DEVELOPMENT REVIEW BOARD – SPEED MEMO

DRB CASE NO: 1001907

SITE PLAN FOR BUILDING PERMIT

Project Name: EAGLE RANCH

SITE PLAN FOR BUILDING PERMIT

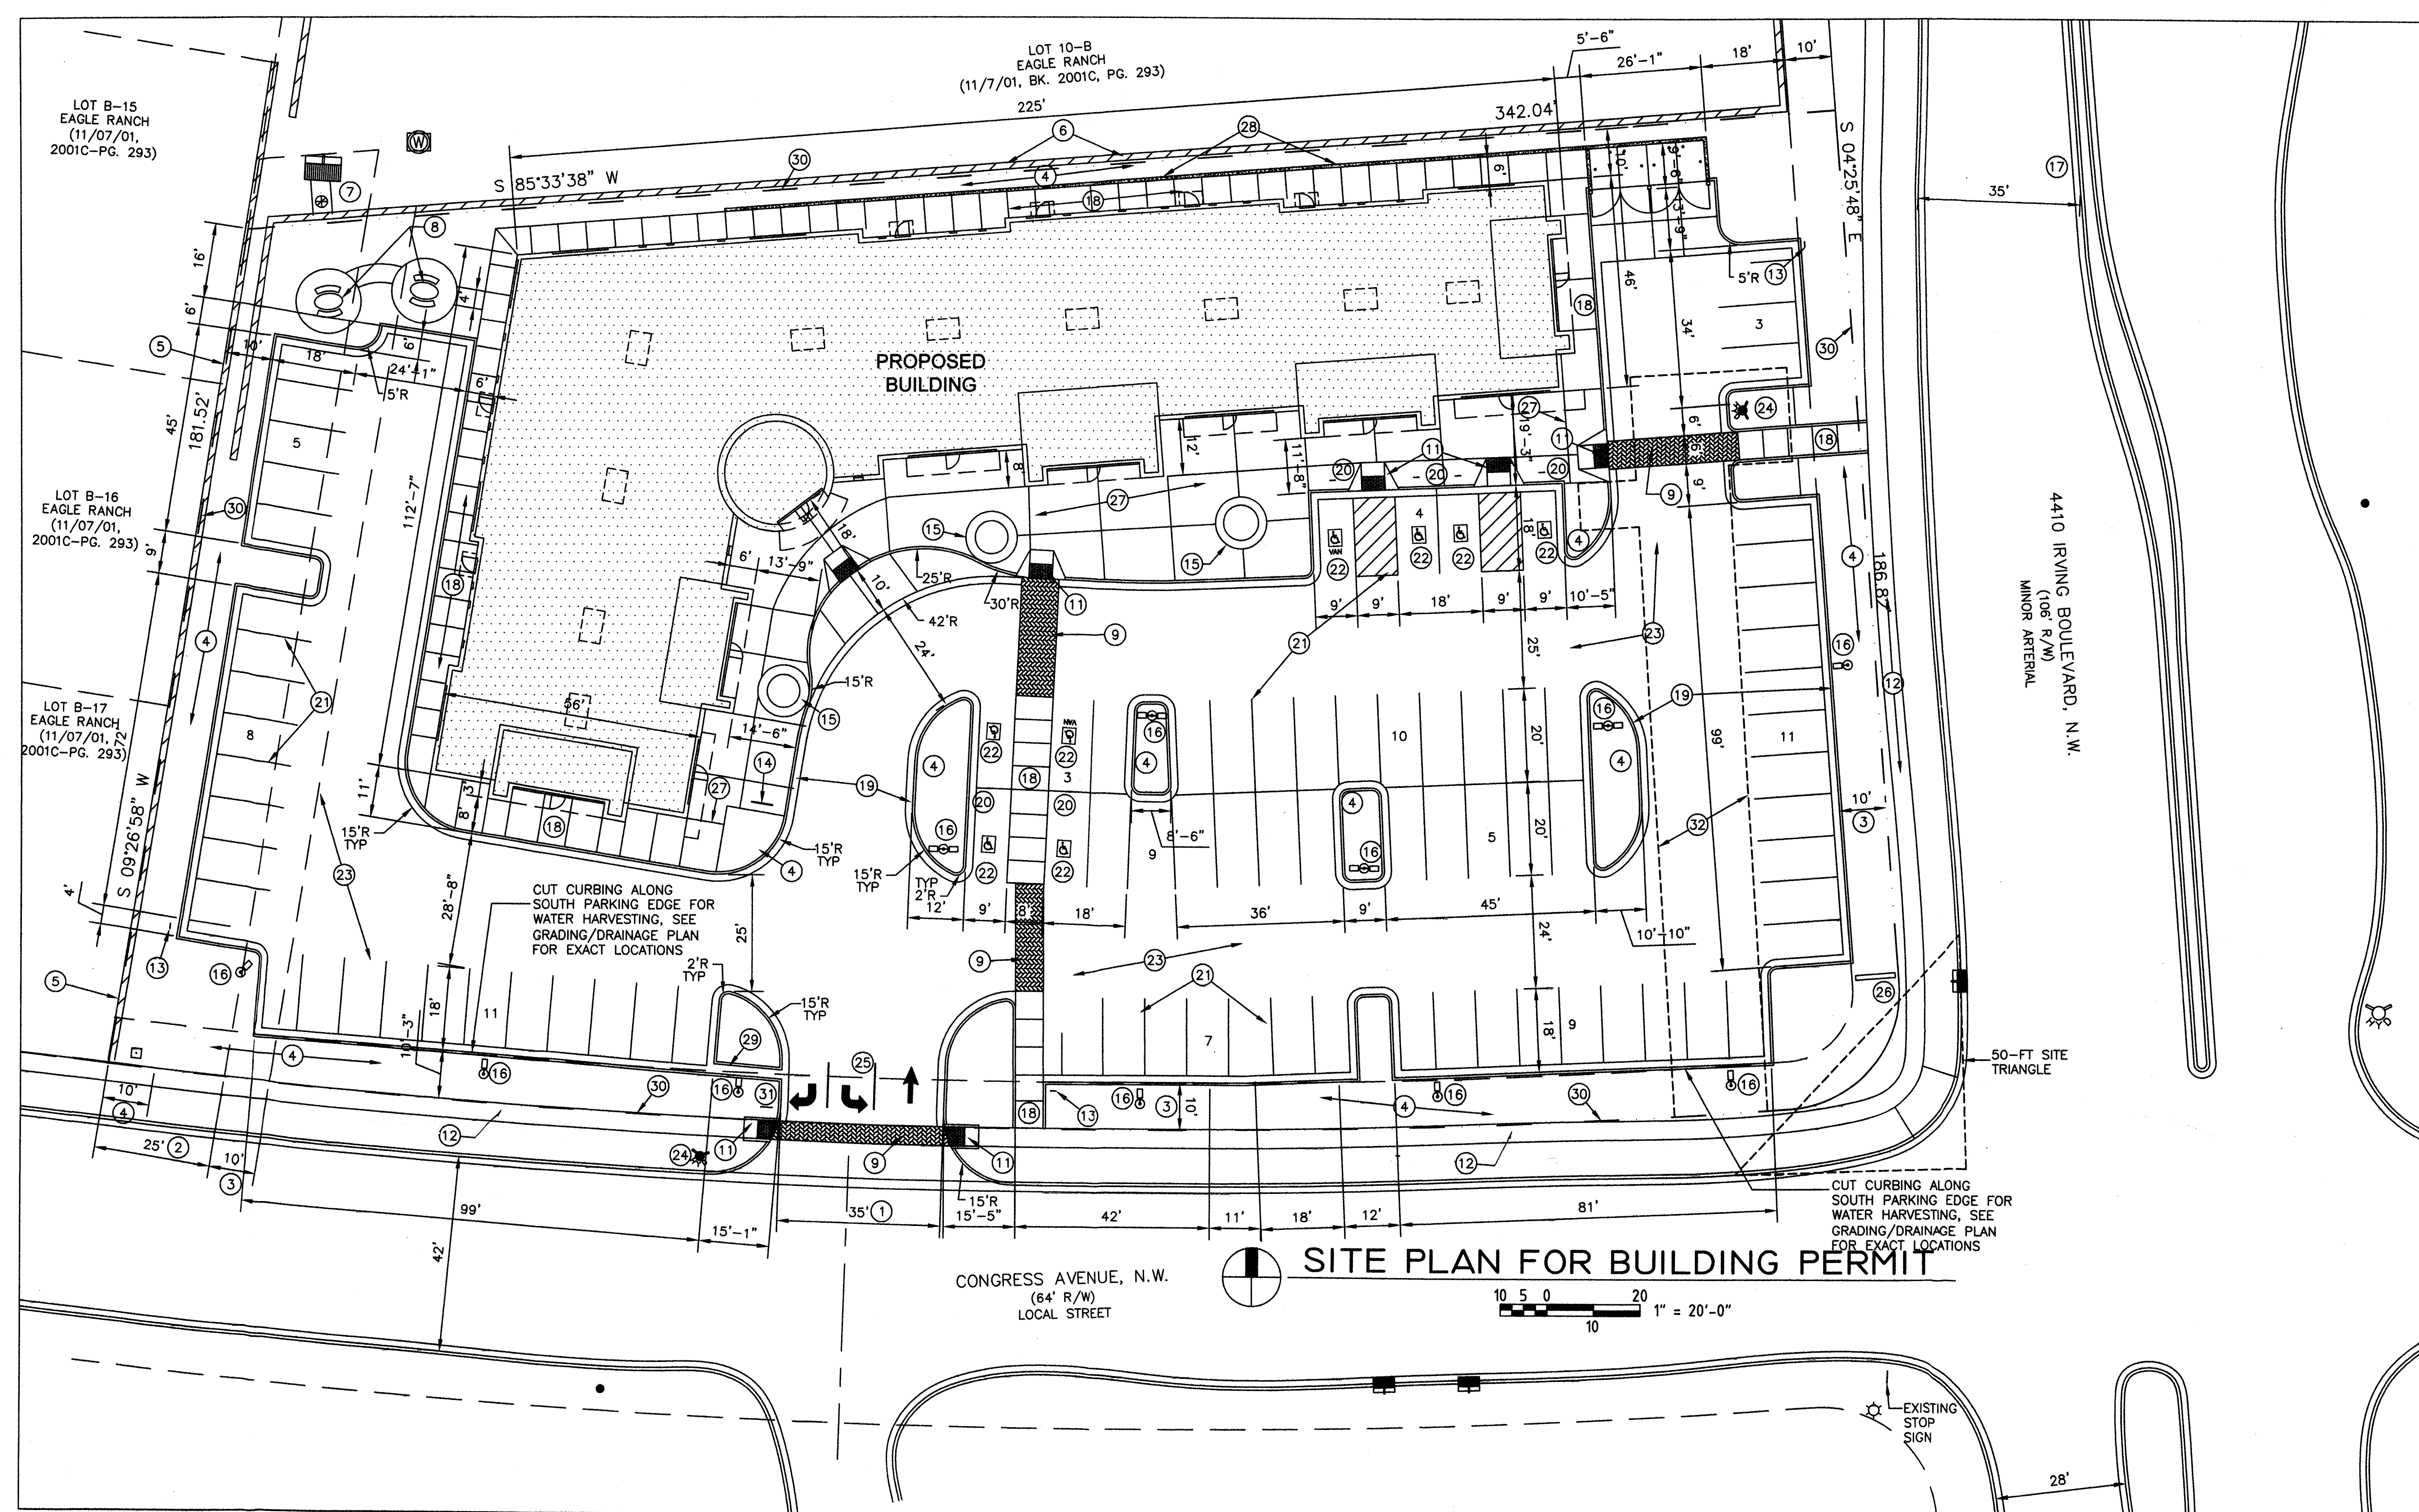
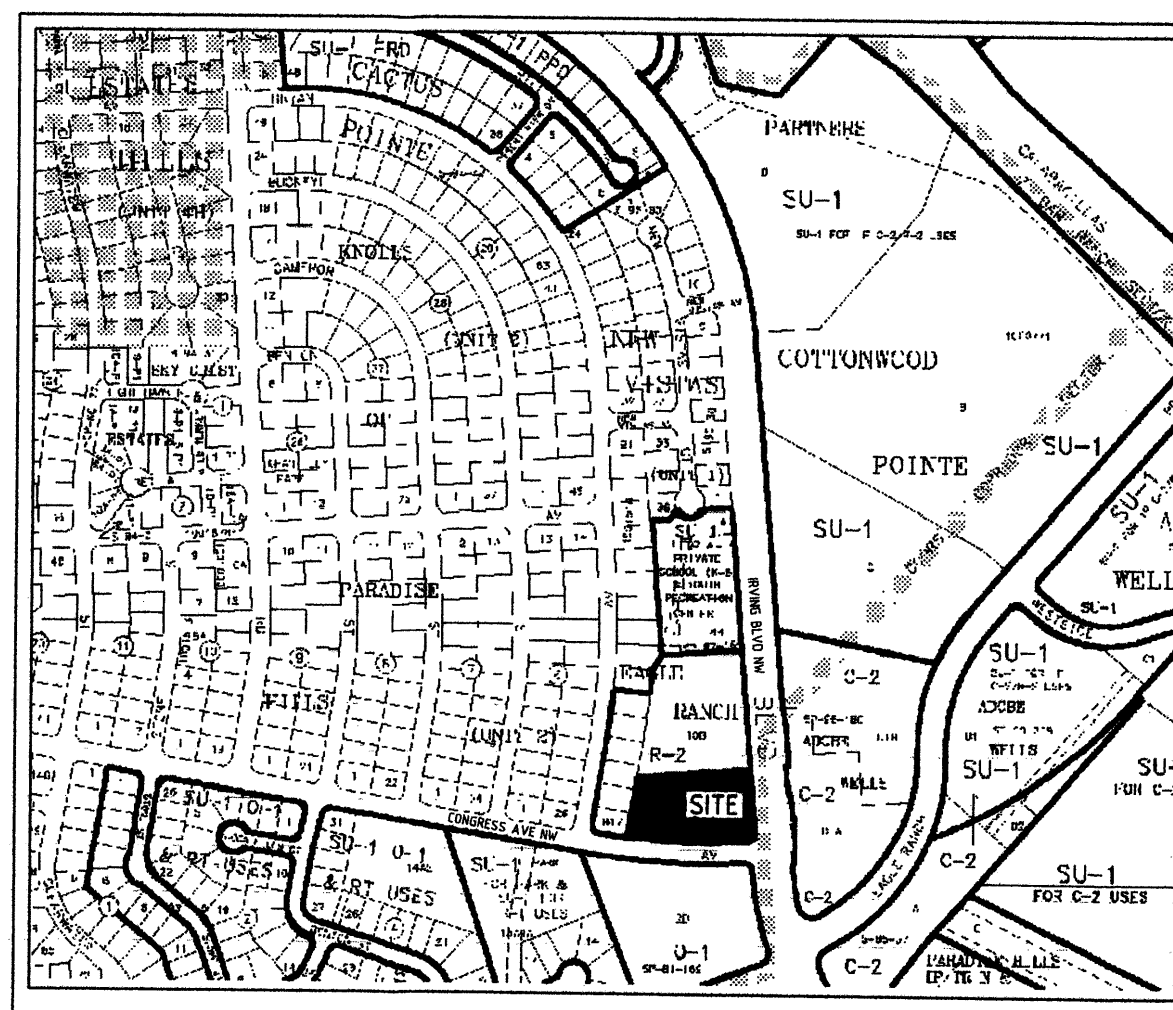
Provide an exhibit showing the location of sidewalk and defining the distance from face of curb to the property line. Right of way dedication may be required.  
Keyed note 1: Curb cut to be built per CoA standard 2426, not 2425.  
Provide details regarding the raised pedestrian walk. How high is the walk raised?  
Is the ramp shown at Irving and Congress existing or proposed?  
Keyed note 12 needs to be relocated along Congress Avenue.  
Call out width of all sidewalk.  
The monument sign appears to interfere with the required intersection sight distance. See Chapter 23, Section 3, Part D.5a of the *Development Process Manual*.  
Call out the width of the keyway.
